**Albuquerque
Metropolitan
Arroyo
Flood
Control
Authority**

July 20, 2015

Re: Presbyterian Paradise Clinic Grading & Drainage Plan, ZAP C-12
Preliminary Plan Dated June 25, 2015

**PARADISE BOULEVARD**

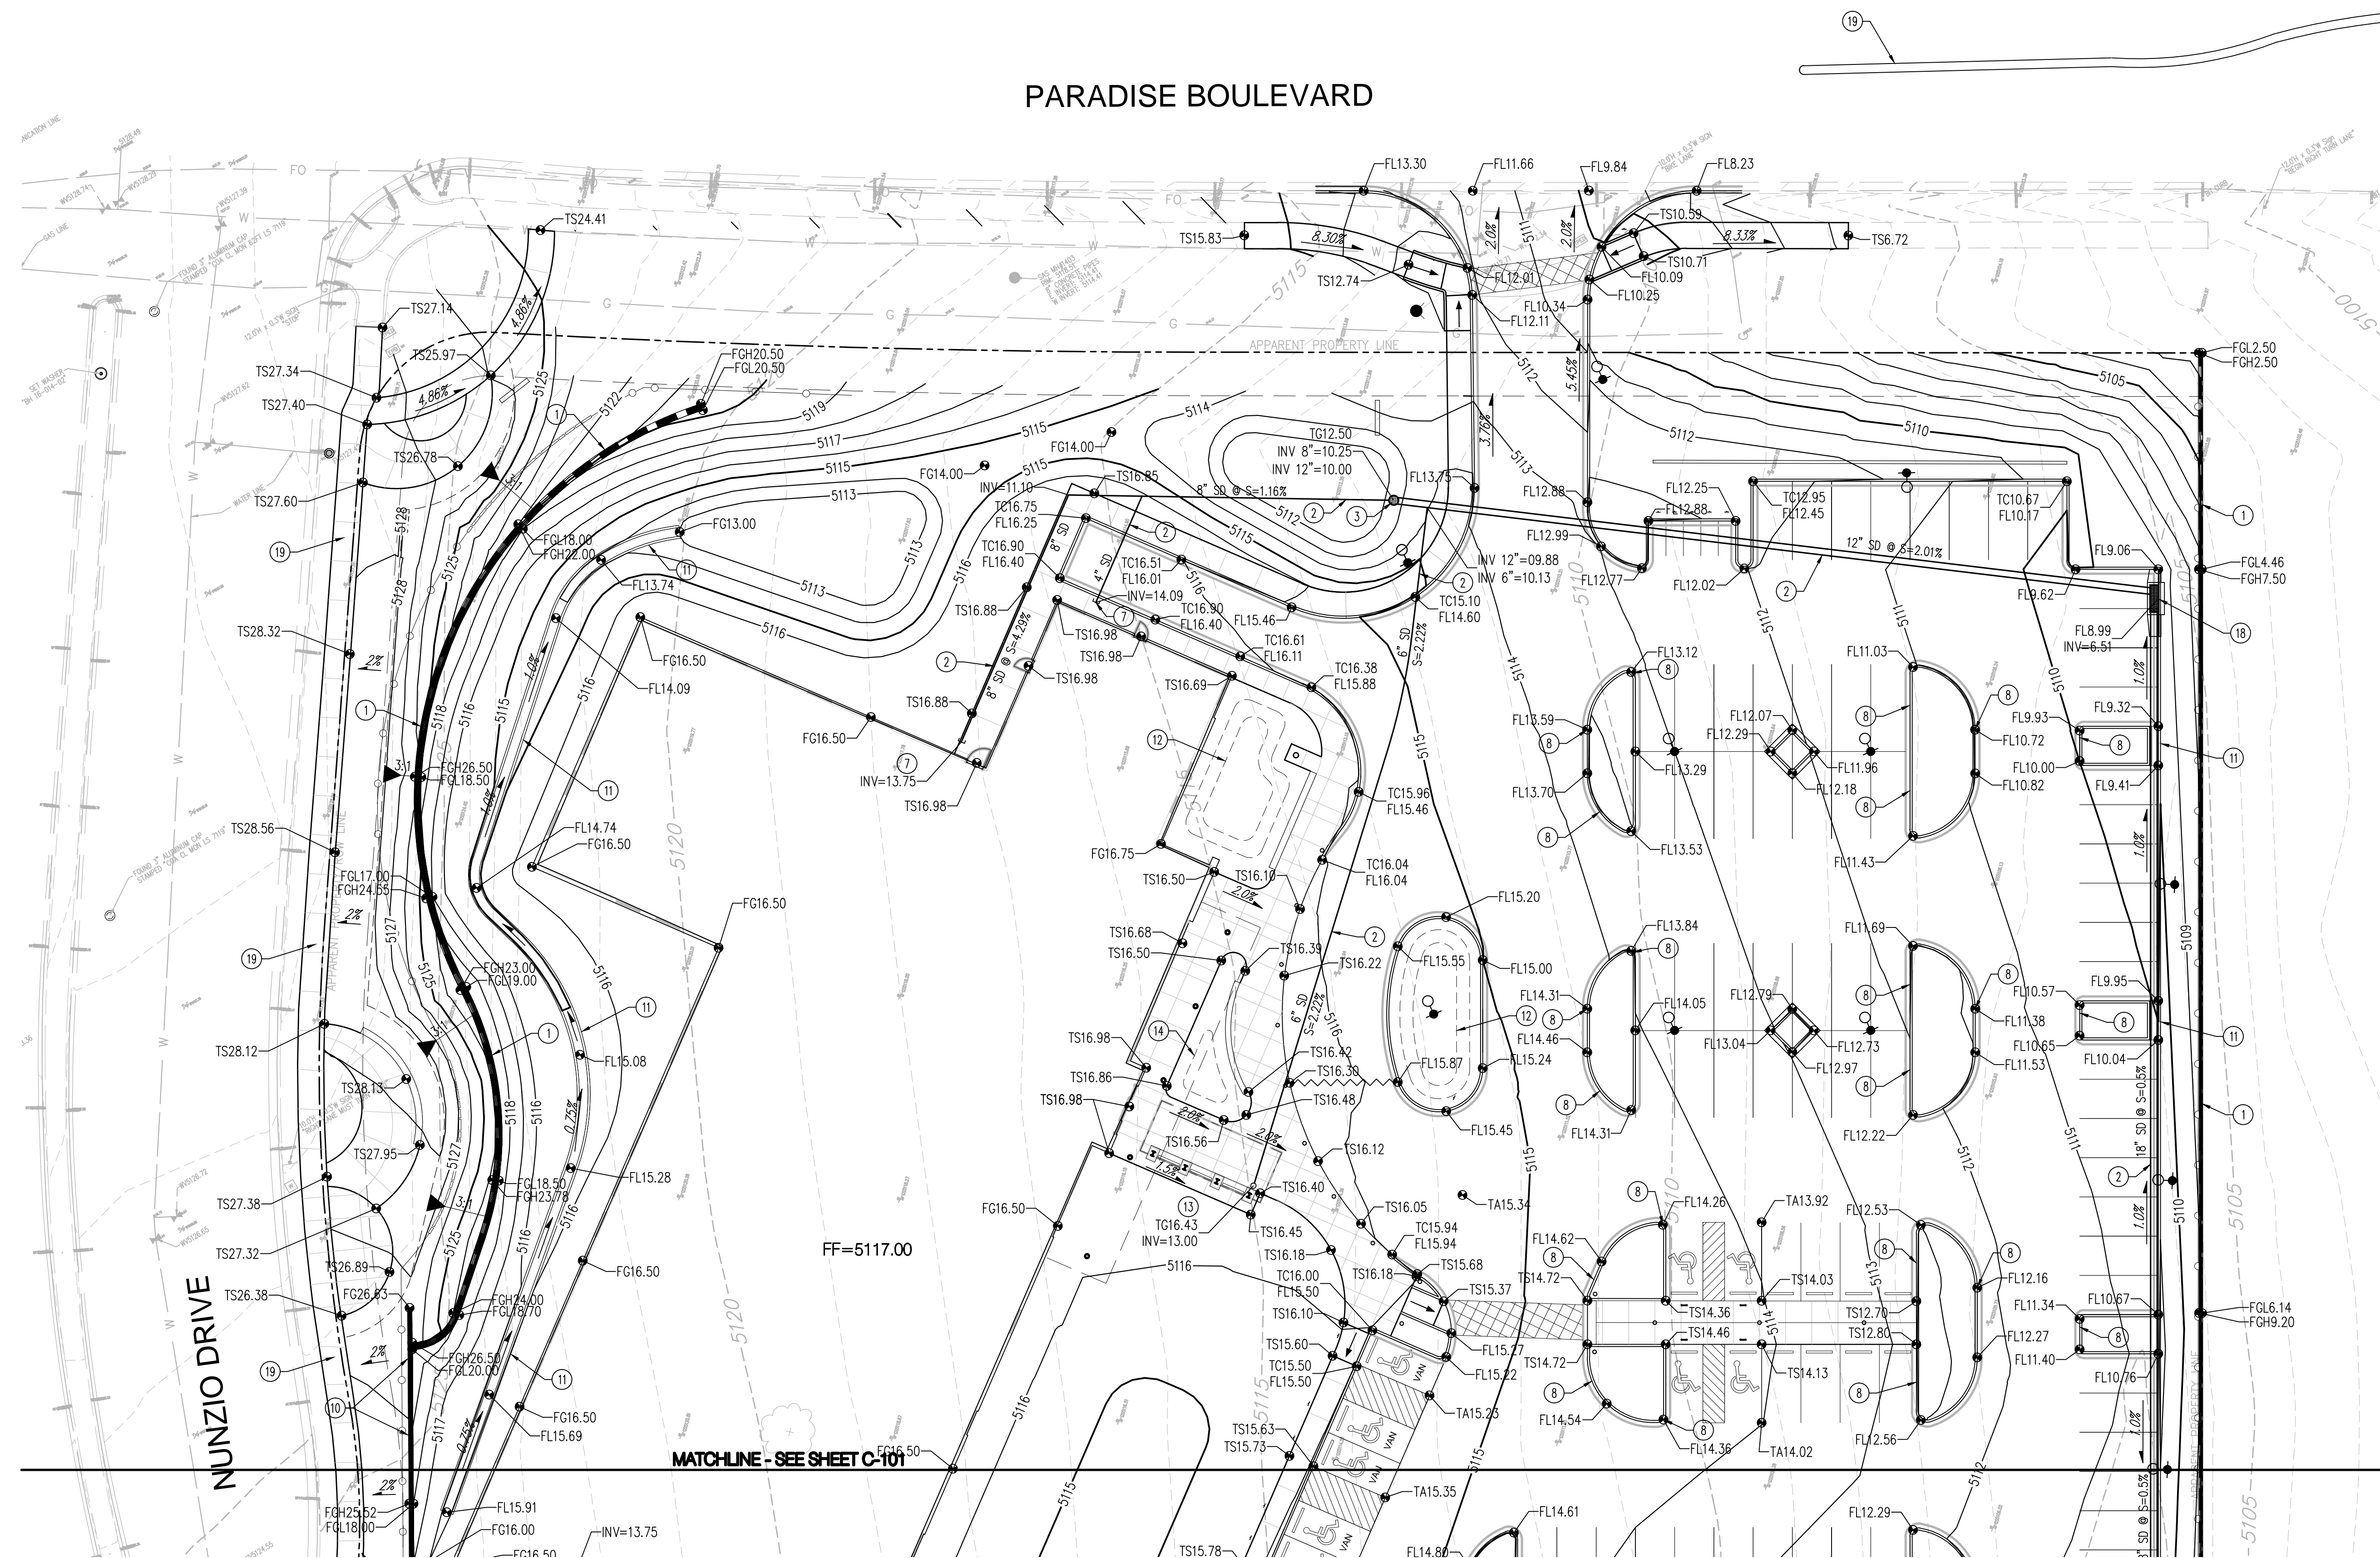
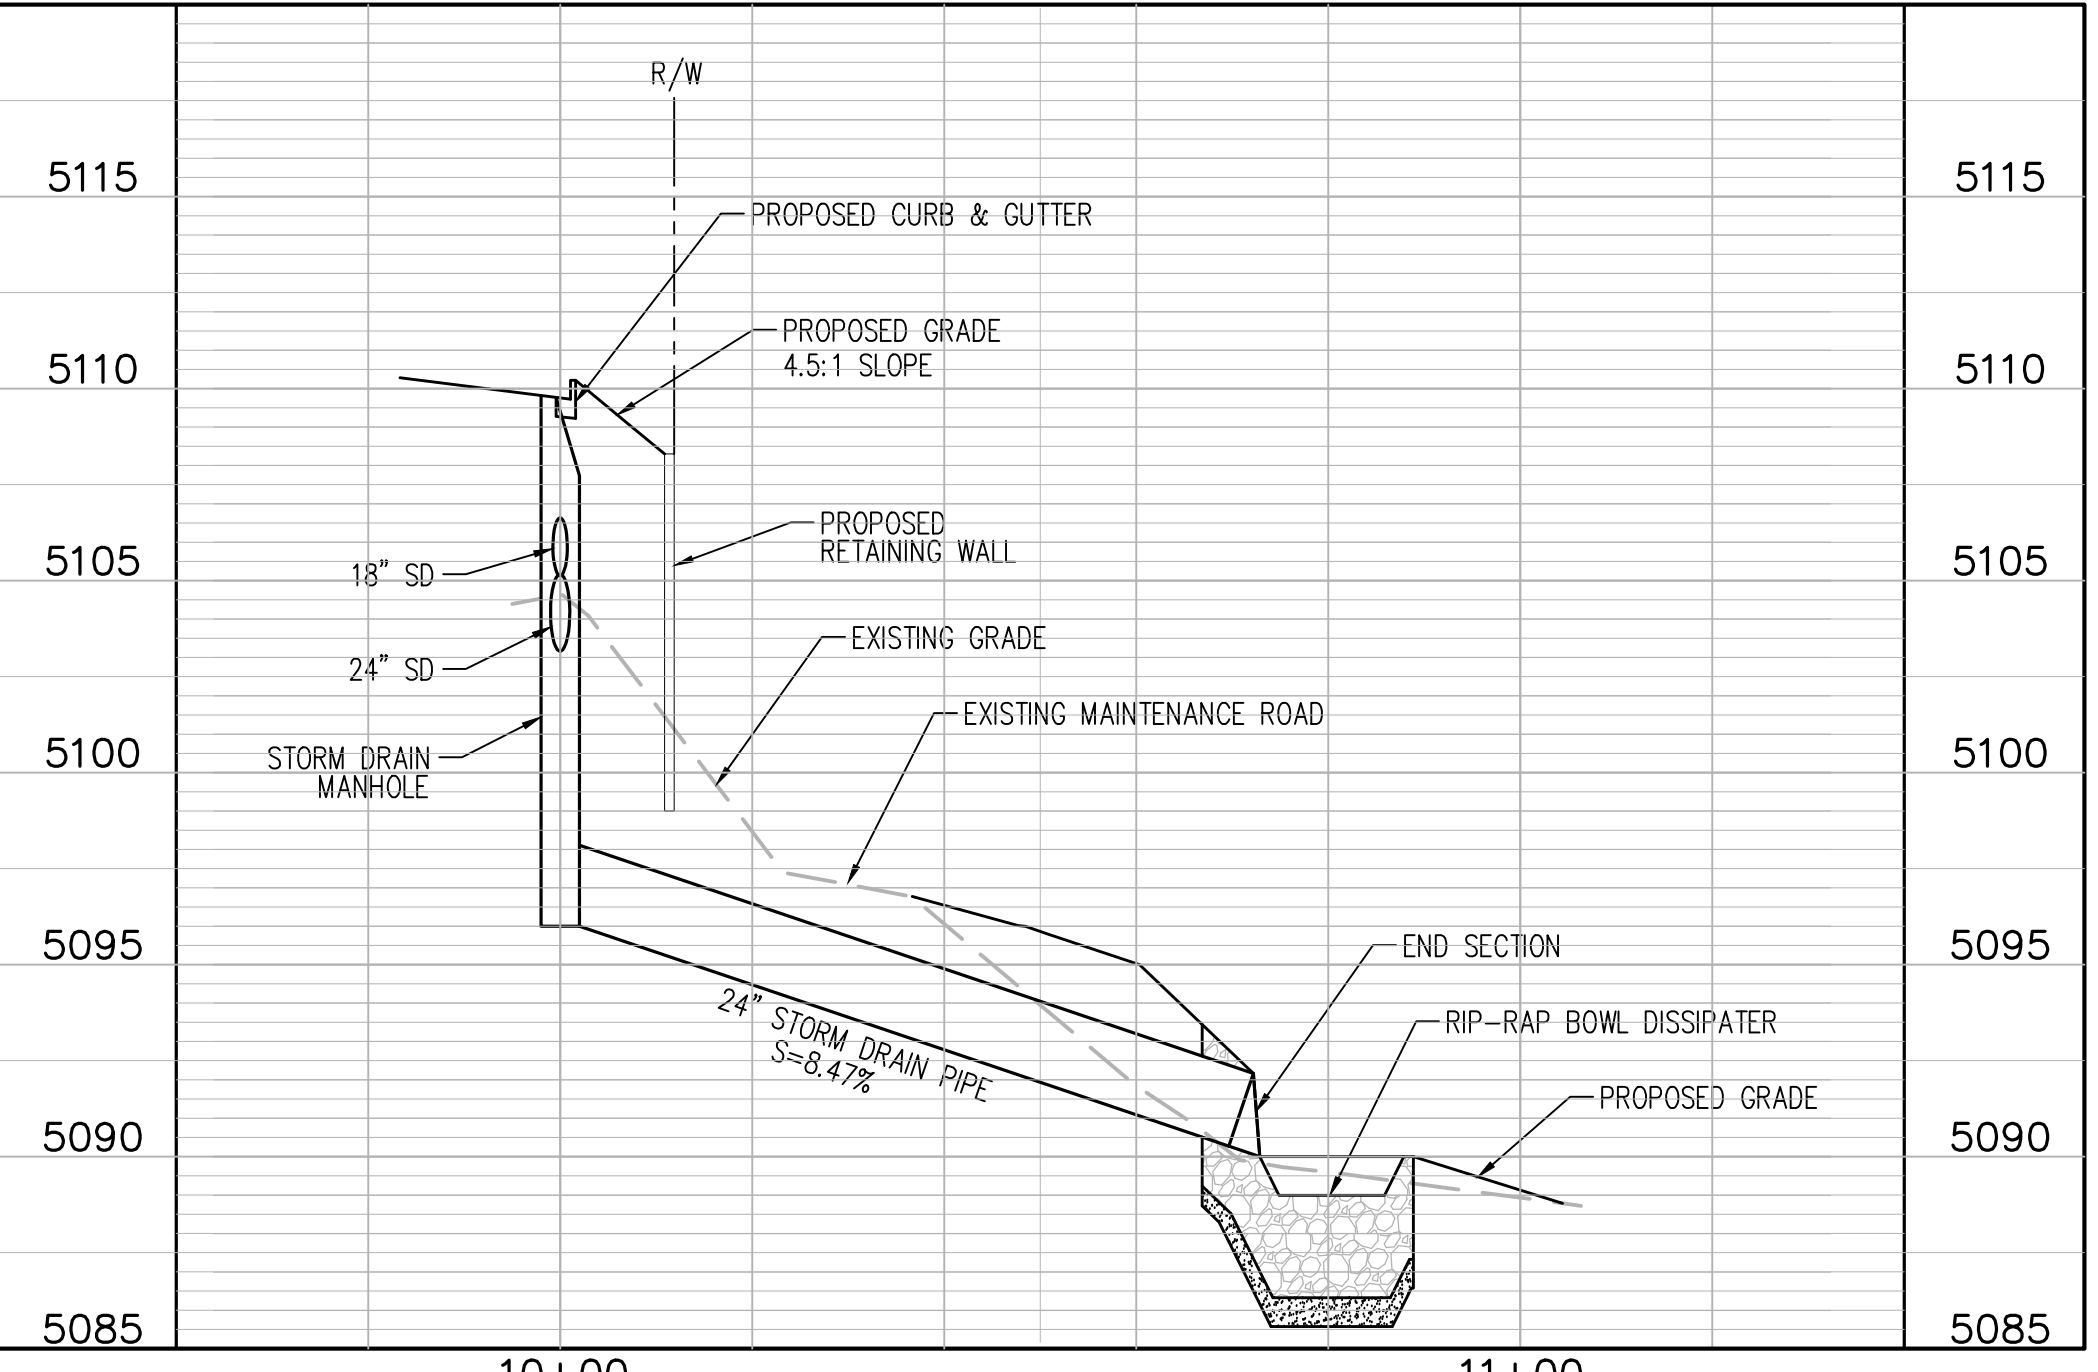
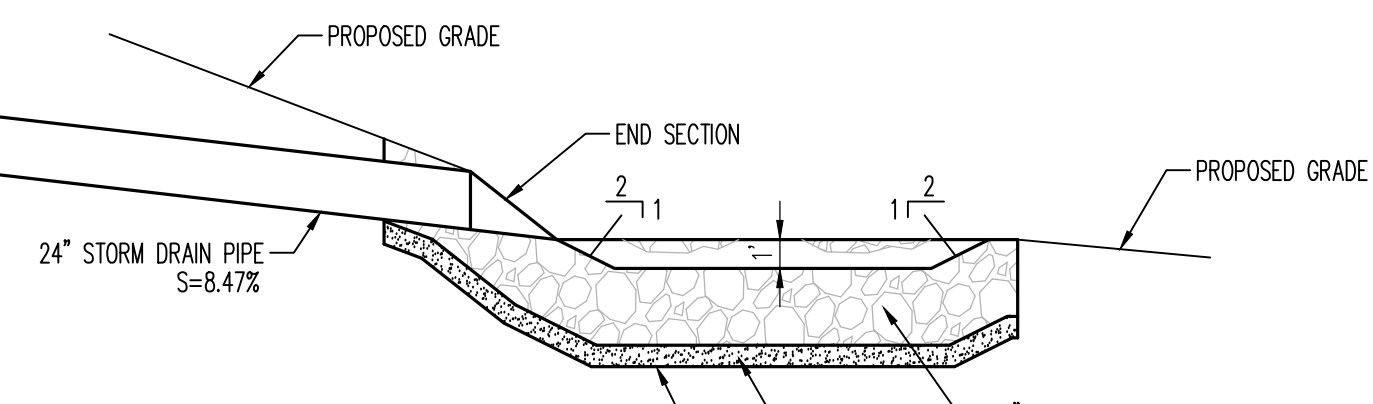
1. Label the AMAFCA right-of-way on the plan. Will there be any space between the retaining wall and the existing maintenance road?
2. Provide a cross-section profile of the pipe connection to the pond. Label all features such as retaining wall, right-of-way, maintenance road, riprap rundown, outfall pipe and erosion control.
3. The slope on the outfall pipe to the pond is 11.7%. What is the velocity? A normal riprap pad will not be adequate for erosion protection. AMAFCA will require a riprap bowl dissipator with riprap protection at the bowl outlet. See attached bowl dissipator design notes.
4. Add a note that the existing wire fence tee posts on the west side of the pond will be salvaged to AMAFCA.
